from
**Southern
Water**

Our ref
PLAN-041641

Proposal: Approval of details reserved by condition imposed under AB/4/18/PL relating to conditions 4-surface water drainage, 5-maintenance & management of surface water drainage & 7-Construction Management Plan.

Site: AB/112/21/DOC: - 1-7 Canada Road, Arundel, BN18 9HZ.

NOTES

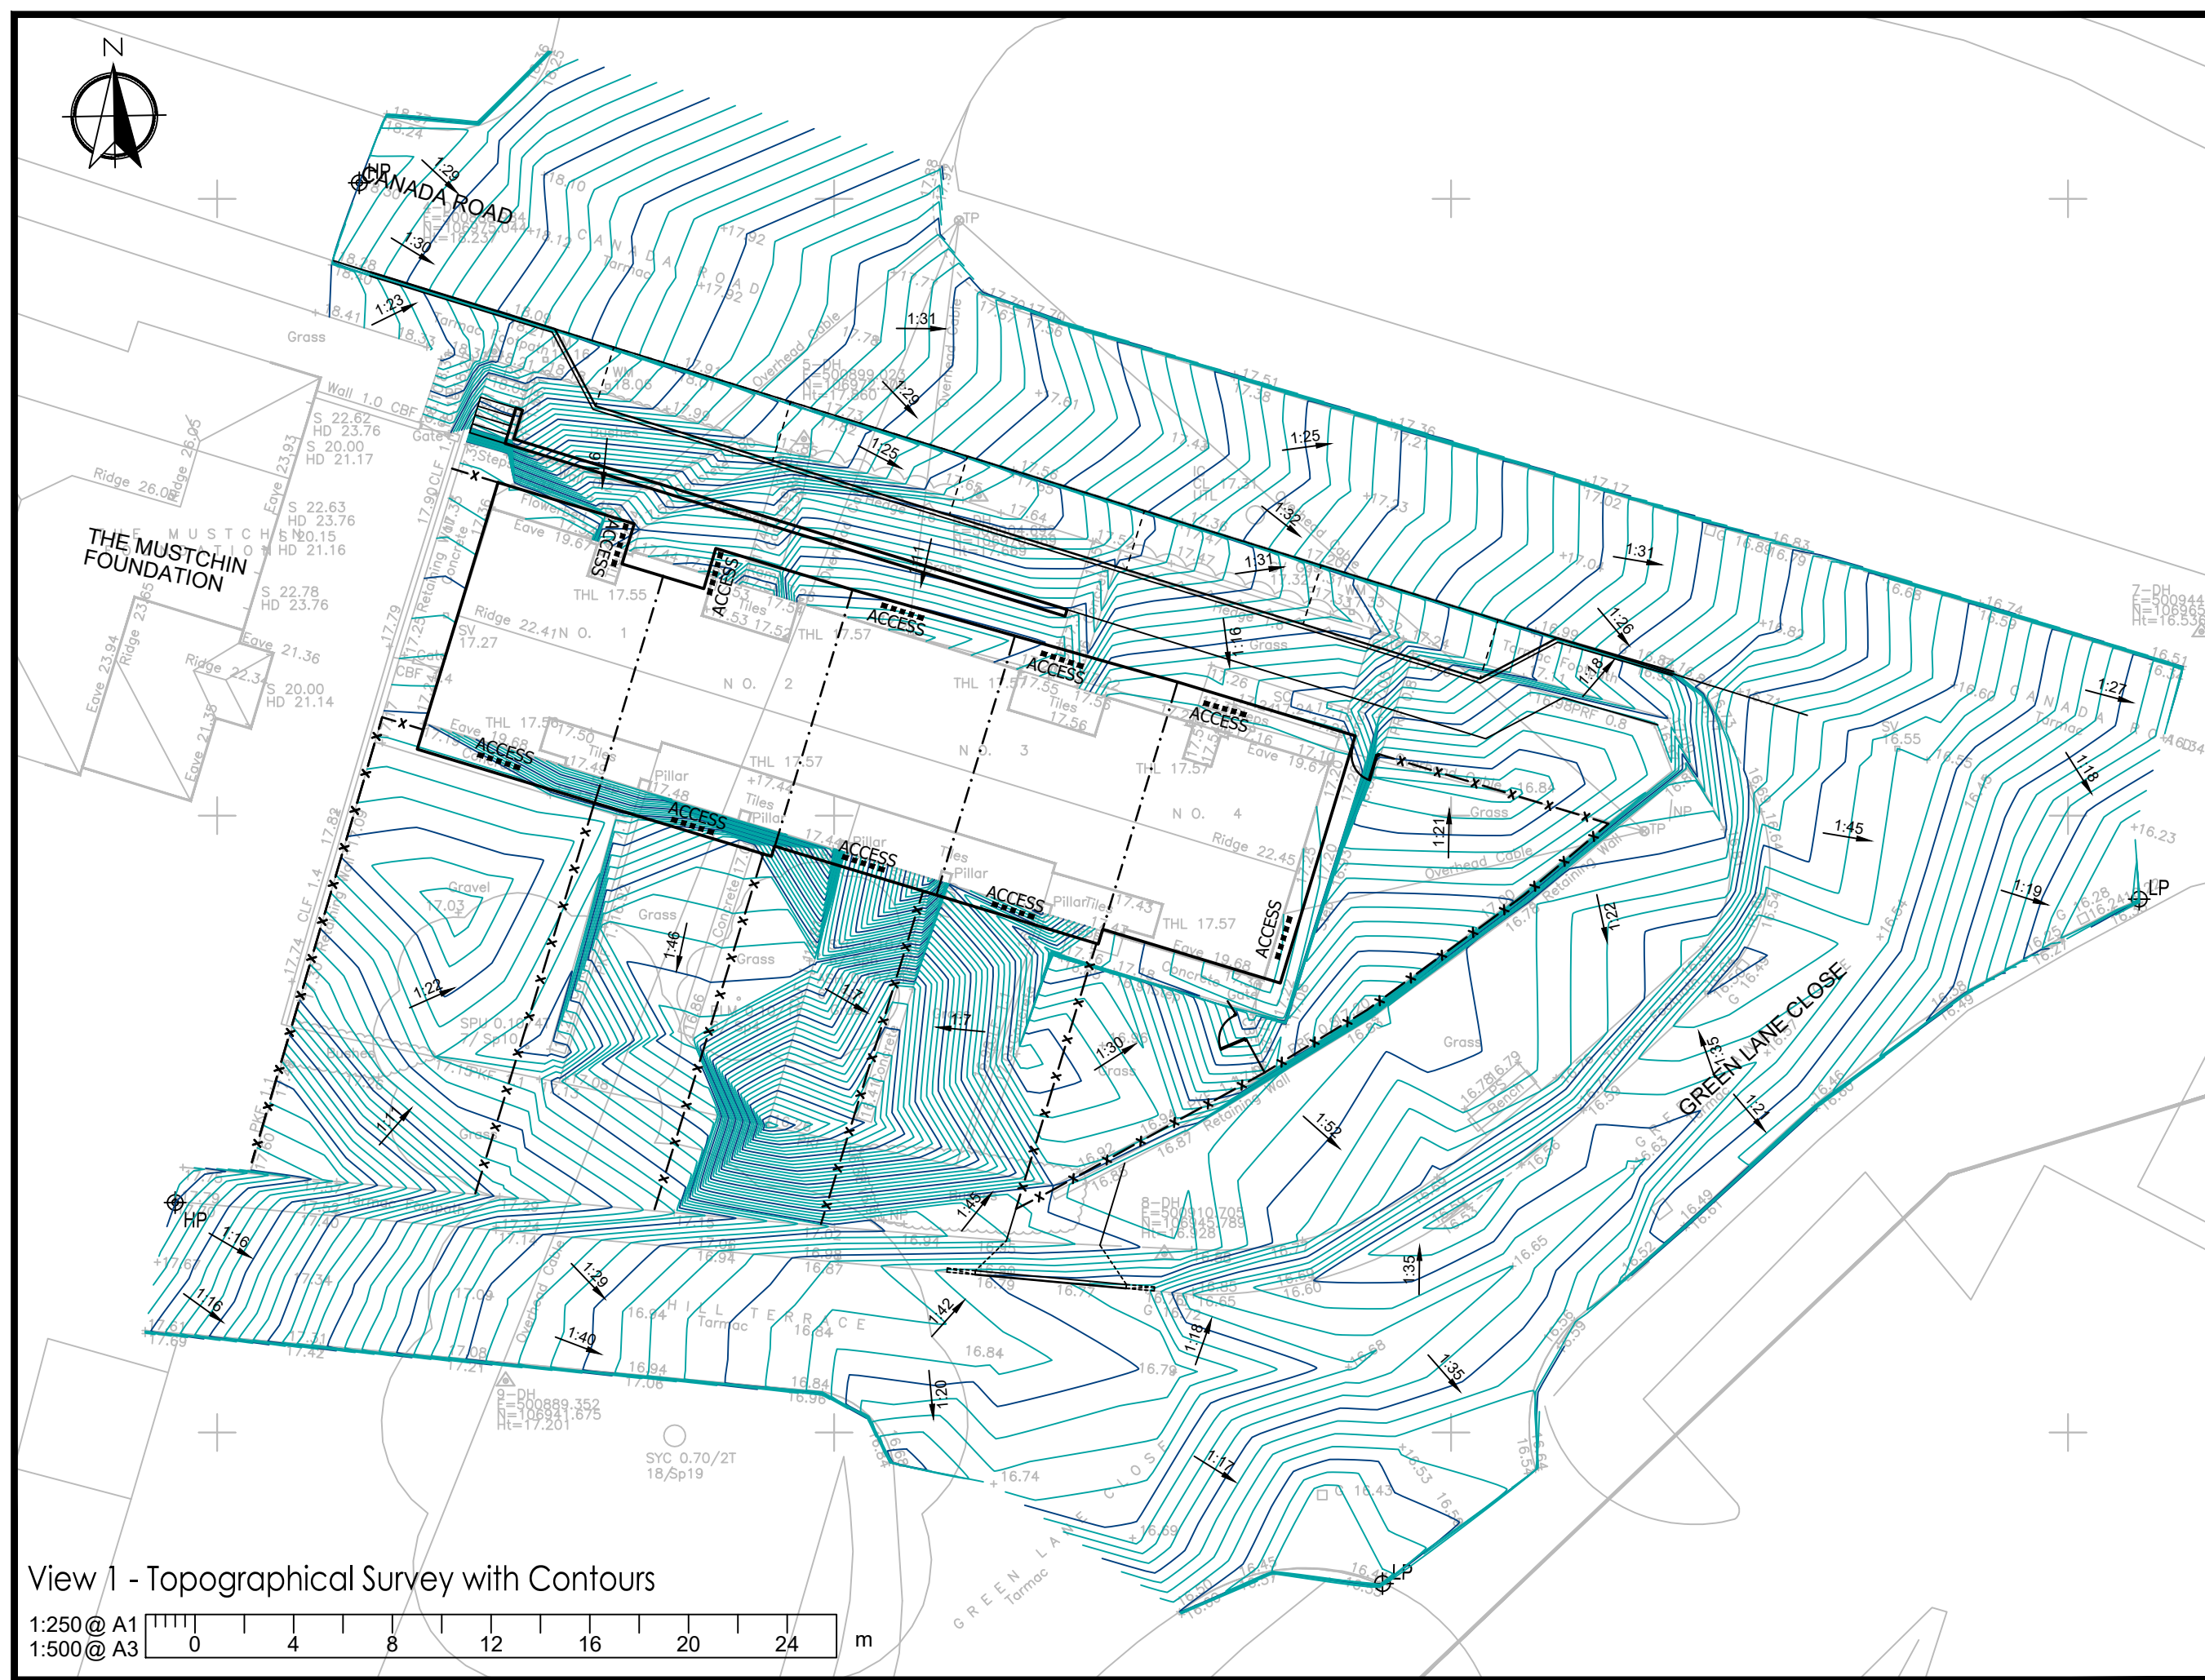
The submitted drainage layout (Drawing No. D1955-4 Rev B) indicates that the proposed surface water flows from the building are reduced from the existing contributing flows limiting to no greater than 2.5l/s to public surface water sewers. Surface water may be discharged to the existing sewer, provided the rate of discharge to sewer is no greater than existing contributing flows.
